Submission ID: 12312

ISH1 Alternative Route Options

ISH 2 Environmental Management Plan, other environmental matters and the DCO

Temple Sowerby to Appleby

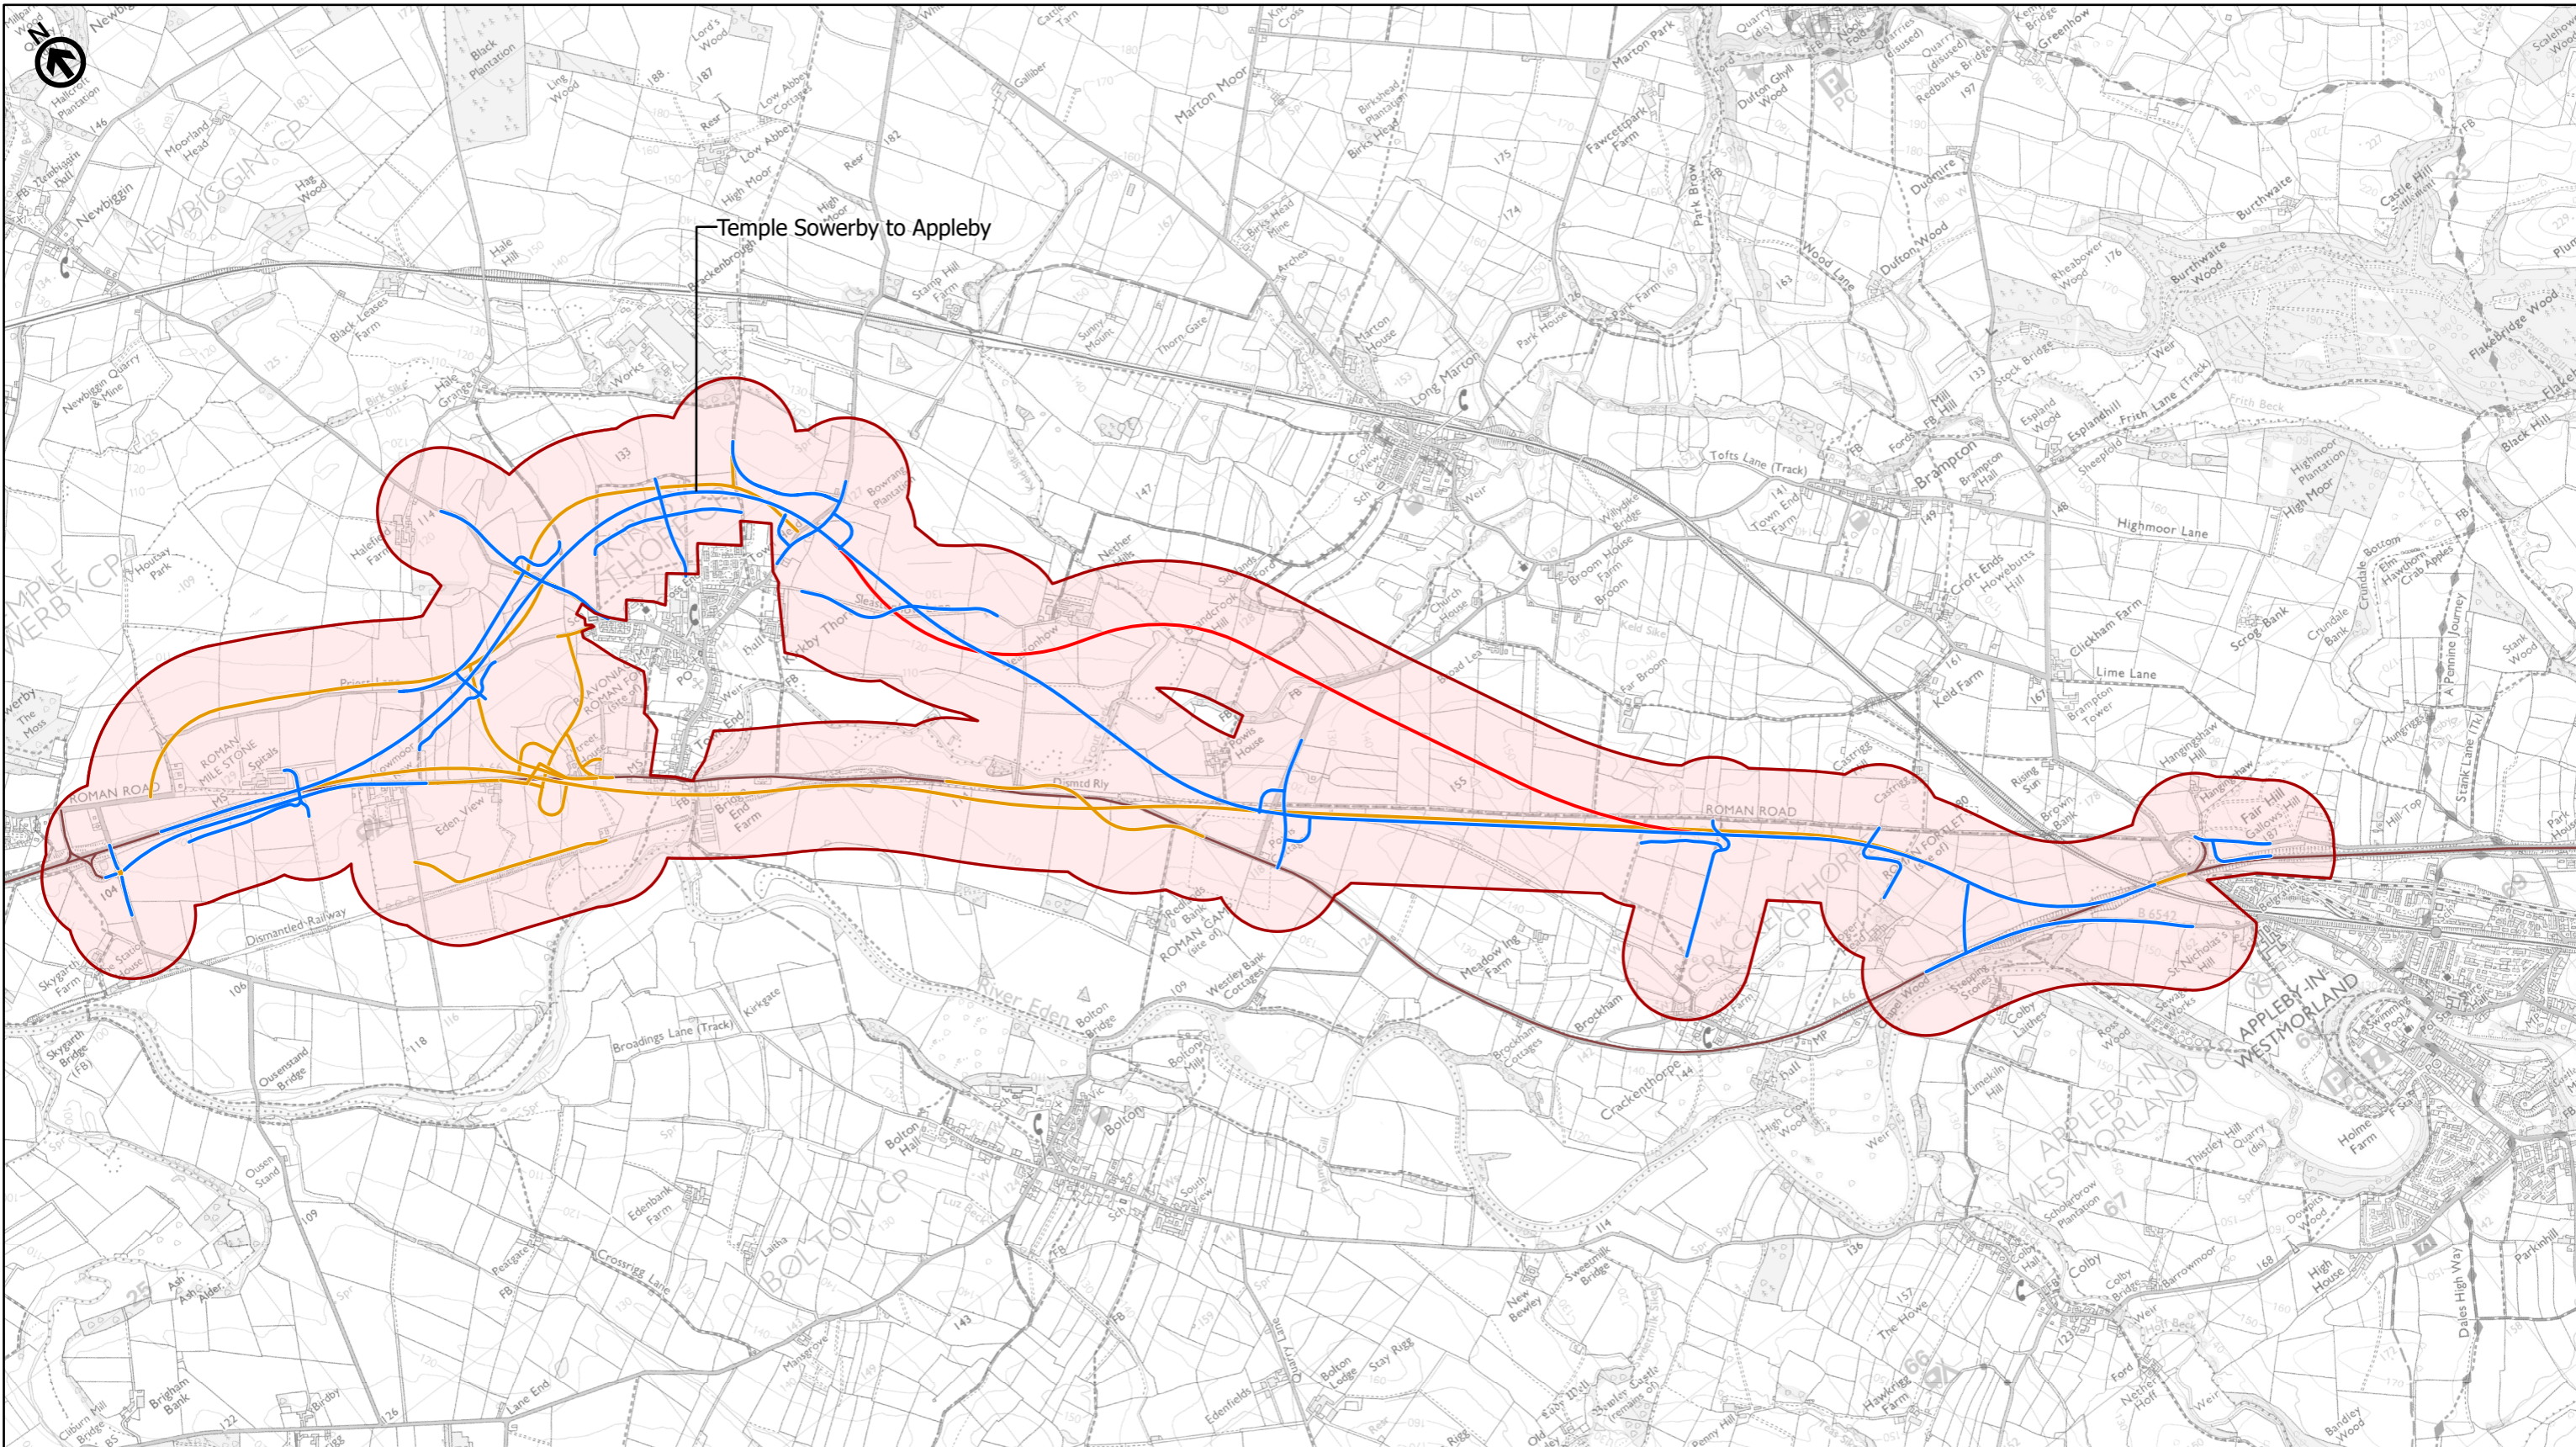
We are particularly concerned about the costs of the Temple Sowerby to Appleby and Warcop stretches along with the increased carbon emissions that a longer, faster route will induce. These two stretches account for more than half the carbon costs of the entire project.
